RE: SITE PLAN – ADMINISTRATIVE DEVELOPMENT FACILITATION TEAM TRACT 52-A, UNIT 2 TRACTS ALLOTTED FROM TOWN OF ATRISCO GRANT PR-2018-001681 SUNSET GARDENS

Development Facilitation Team (DFT) – Review Comments

Project No: PR-2018-001681 Date: 03/06/2024 Agenda Item: #1 Zone Atlas Page: MX-L

Application For: SI-2024-00271 – SITE PLAN DFT

SEAL	DESIGNED	PROJECT NO
	DRAWN	SCALE
	CHECKED	DRAWING NO
	REVIEWED	A-201.1.0
	DATE 1/10/2023

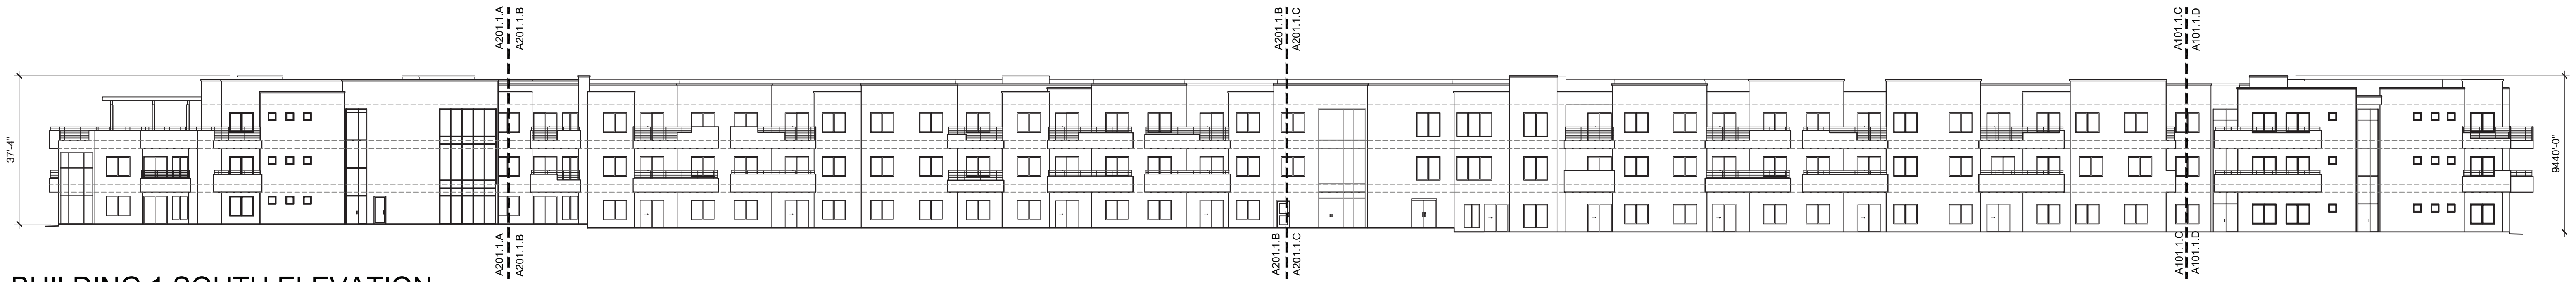
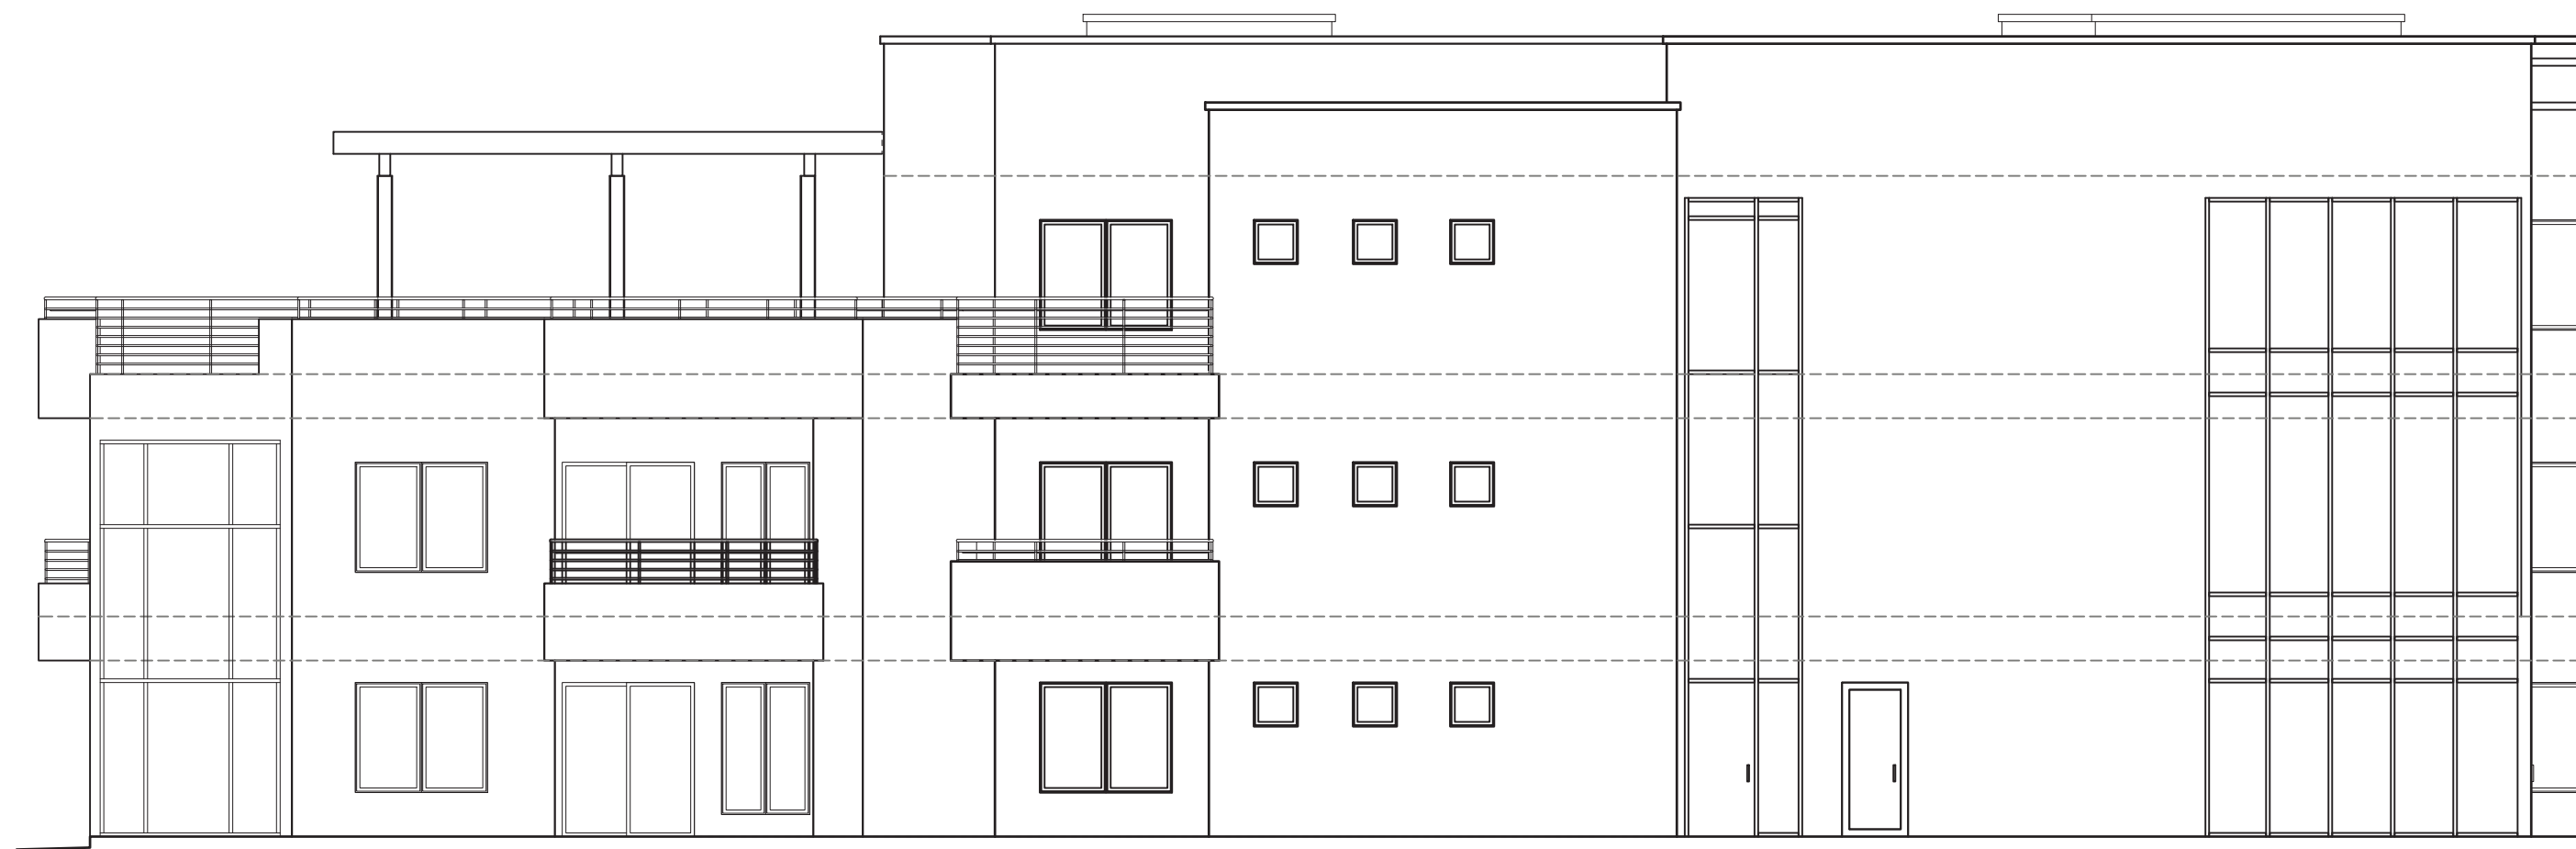
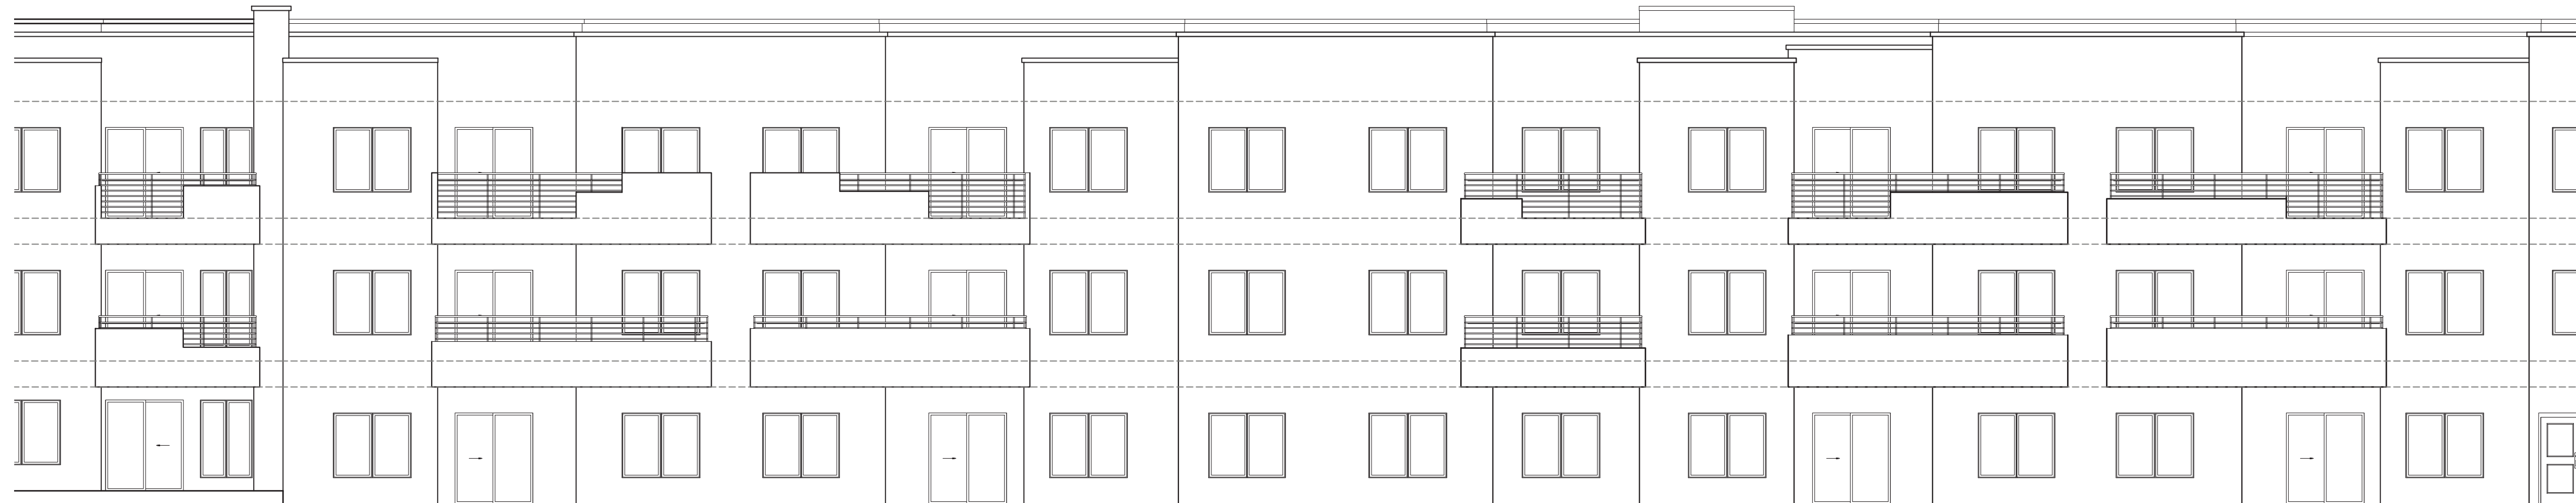
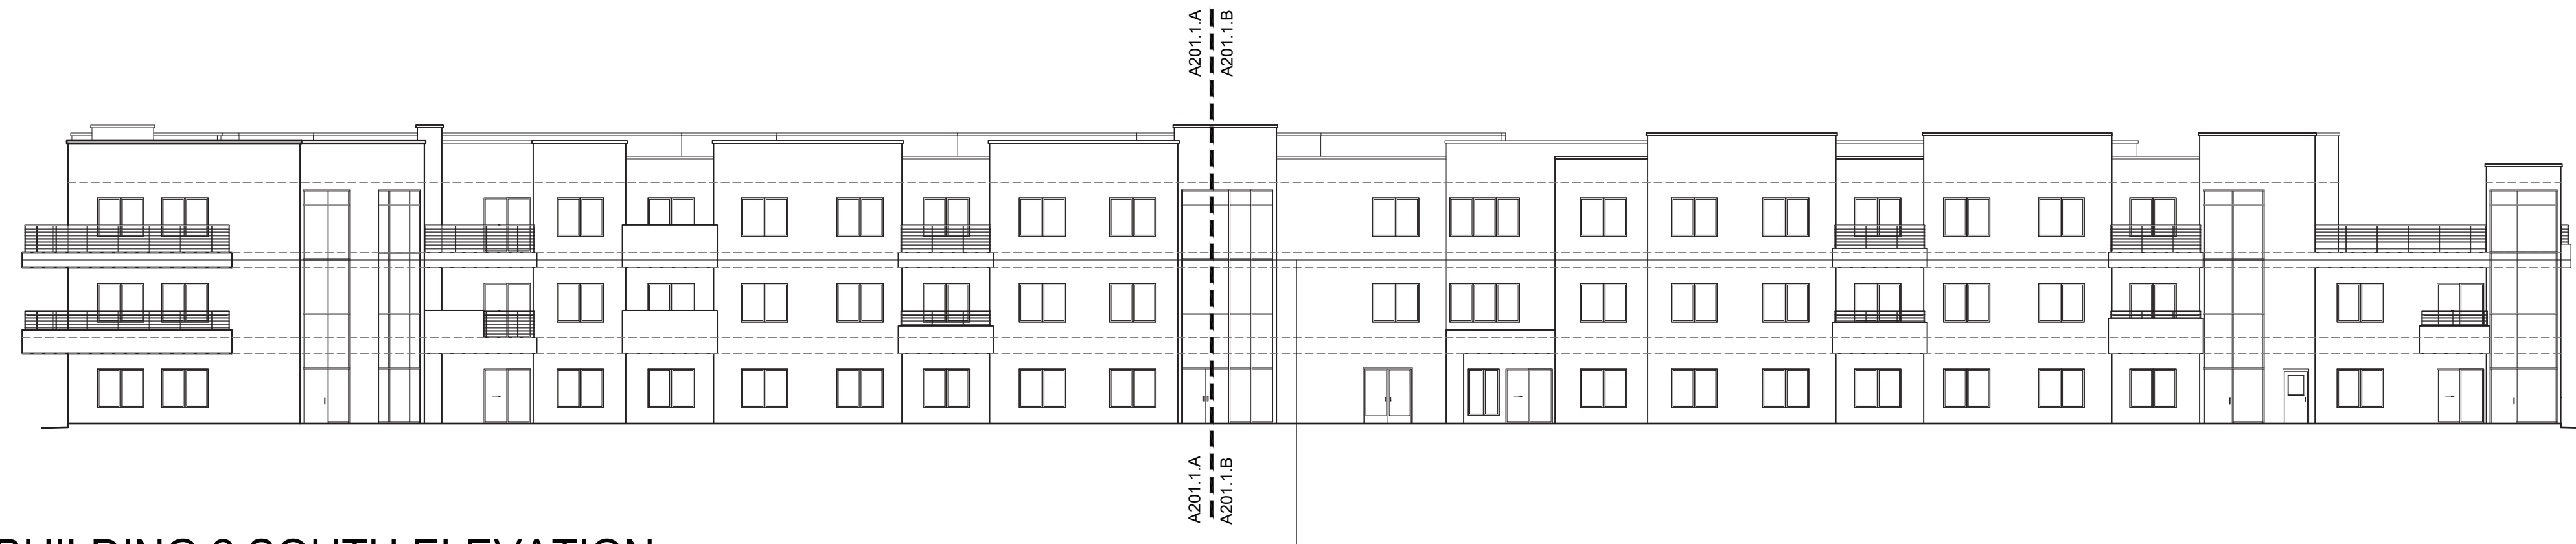
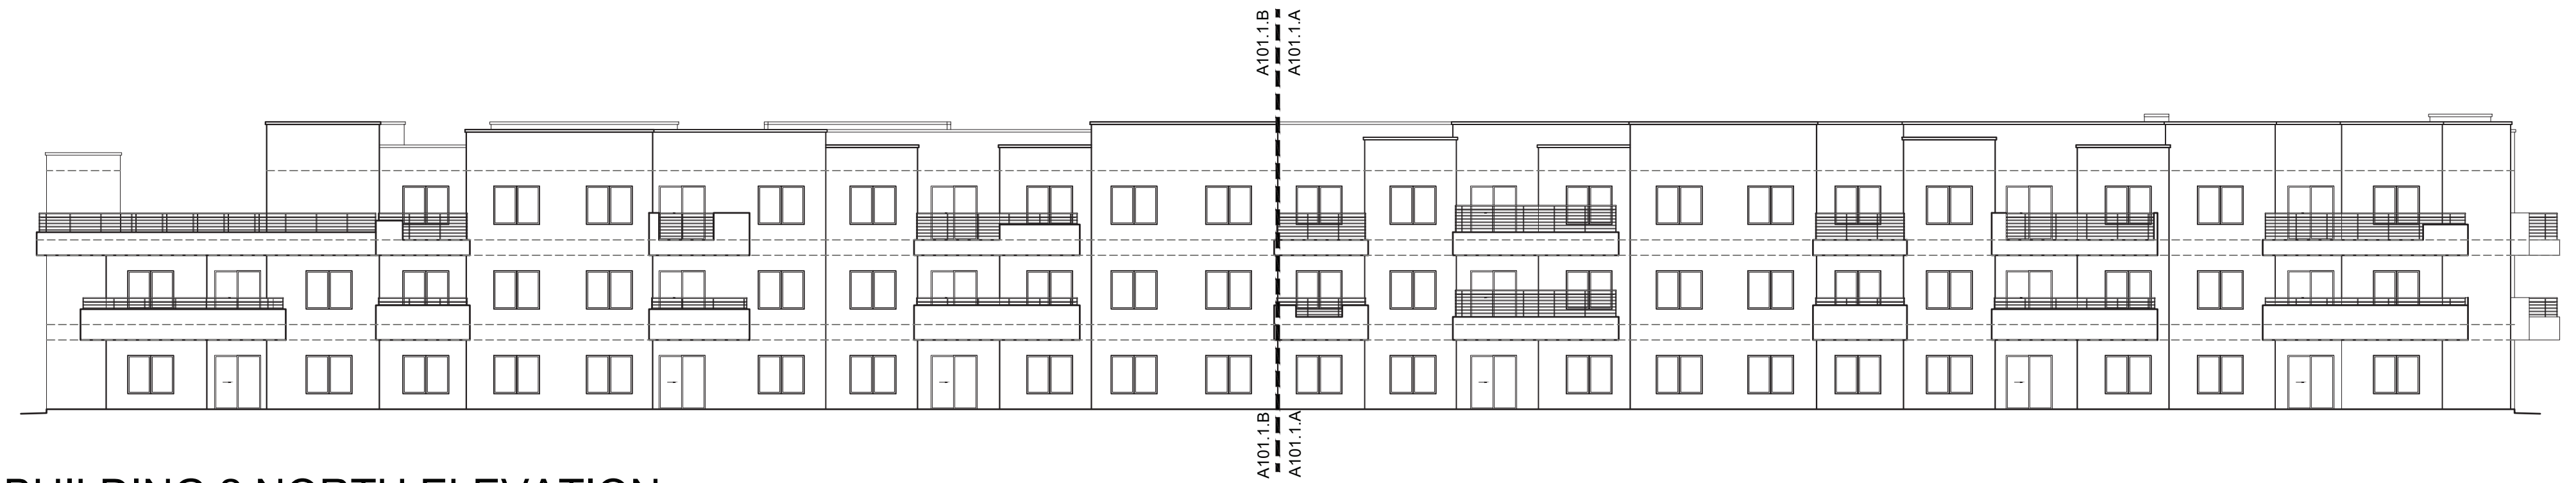
8. Provide building designs as per 14-16-5-11(D) (Entrances, Façade and Articulation designs as per 2inch window recess and west side heat mitigation features)

- 9. Provide Entrance features for all buildings facing the parking lot, show color variations. RESPONSE: Refer updated building elevations and are designed per 14-16-5-11(D).
- 10. Show the location of the EV charging equipment.

-Maximum Building Height: 38 ft. / proposed Building Height: 38'-4" — Please address RESPONSE: Revised building heights to 38'-0".

RESPONSE: Refer updated building elevations and are designed per 14-16-5-11(D).

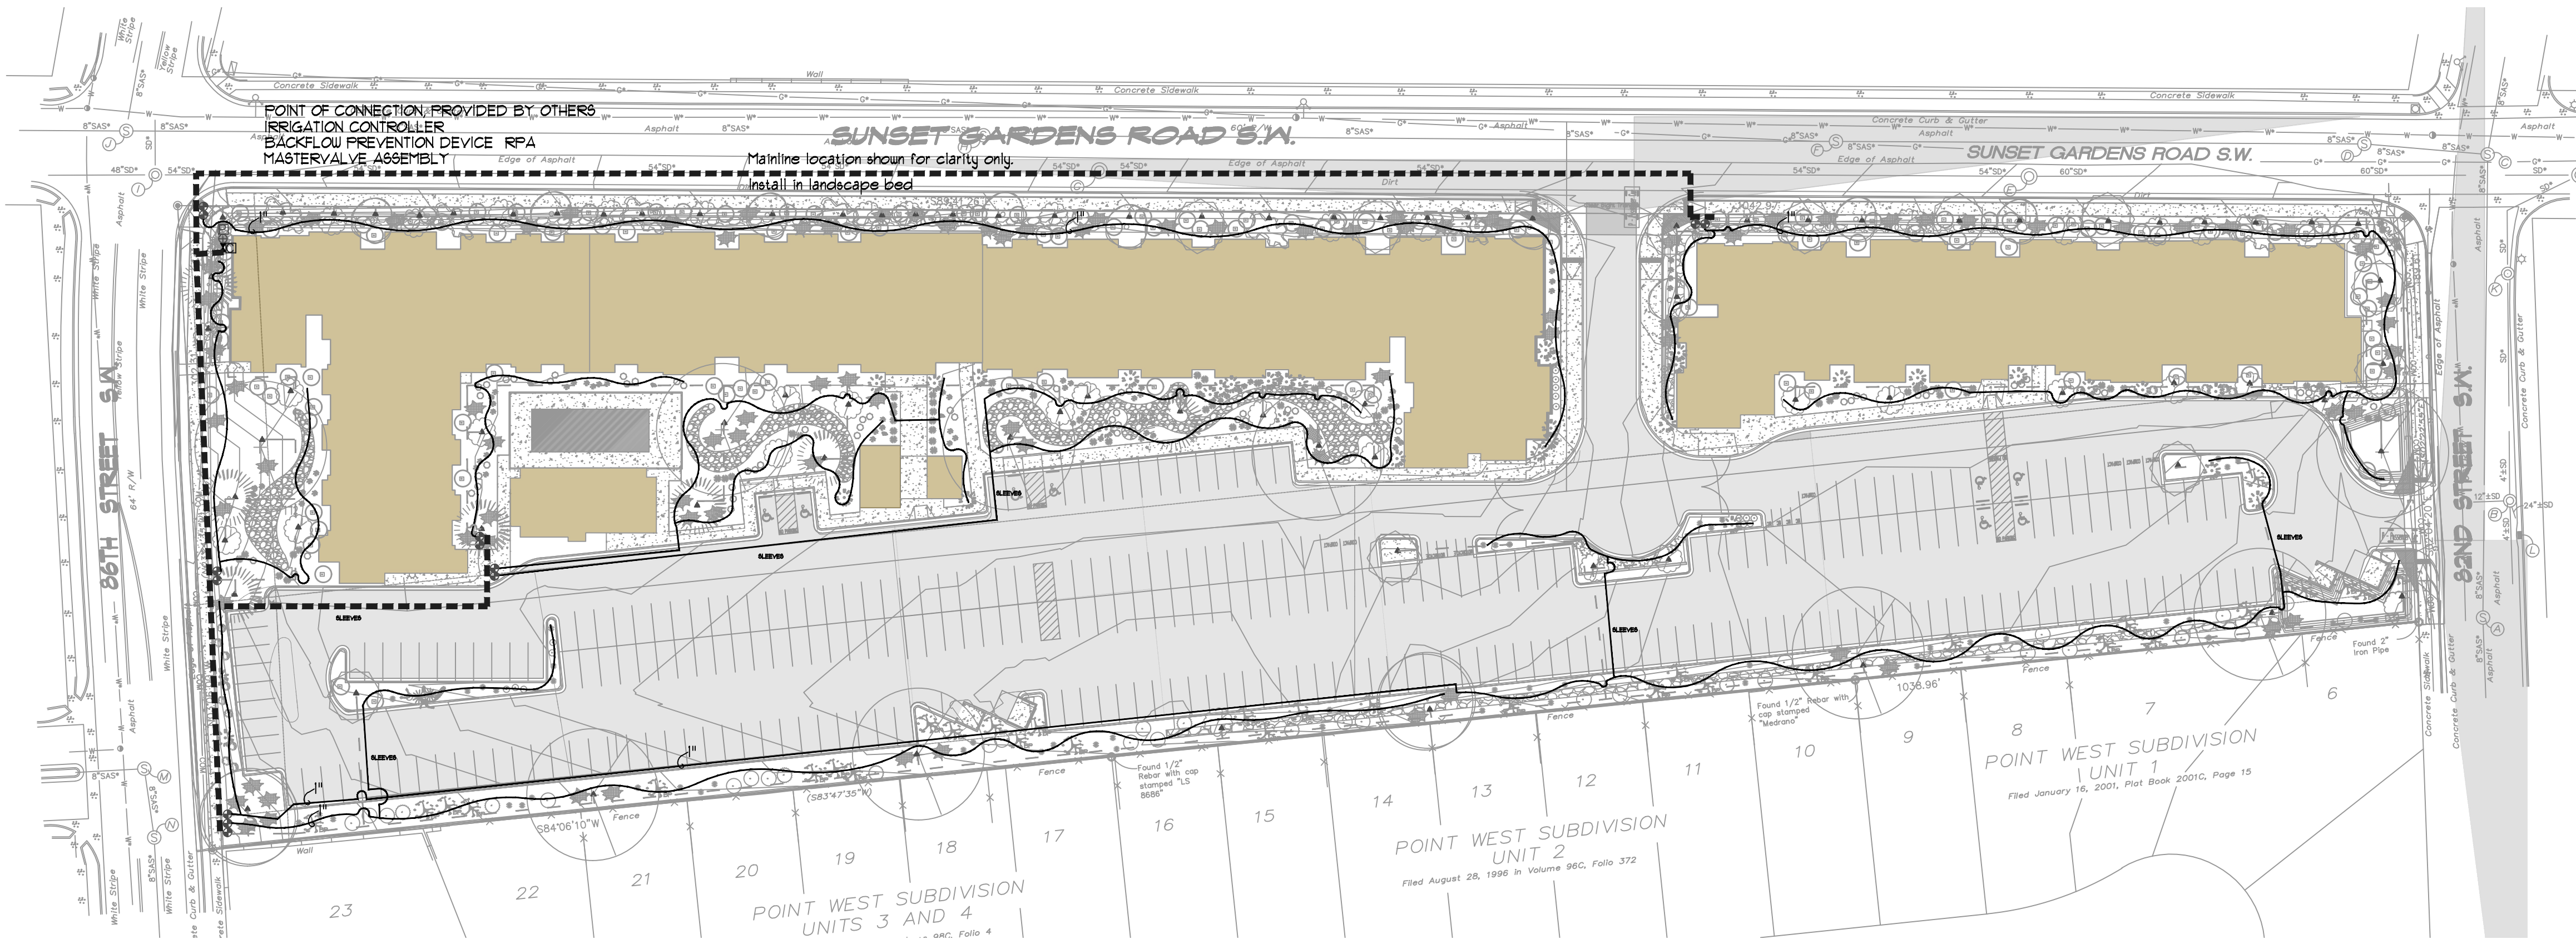
3. Provide landscaping Edge Buffer landscaping as per 14-16-5-6(E)(2)(a) zone to the south is R-1B in an area of consistency.

4. Provide parking lot landscaping as per 14-16-5-6(F)(1)(i)(2) and parking lot trees as per 5-6(F)(2)

7. Indicate how many units are on the ground and second level and provide tree count accordingly as required by 14-16-4-3(B)(c)

Please confirm compliance with this code. Minimum required landscape area does not match the number on the Site Plan.

RESPONSE: See updated landscape plan LS-101.

RESPONSE: See updated Landscape Plan LS-101.

RESPONSE: Refer updated landscape sheet LS-101 for landscape calculations.

RESPONSE: Confirmed see updated landscape sheet LS-101.
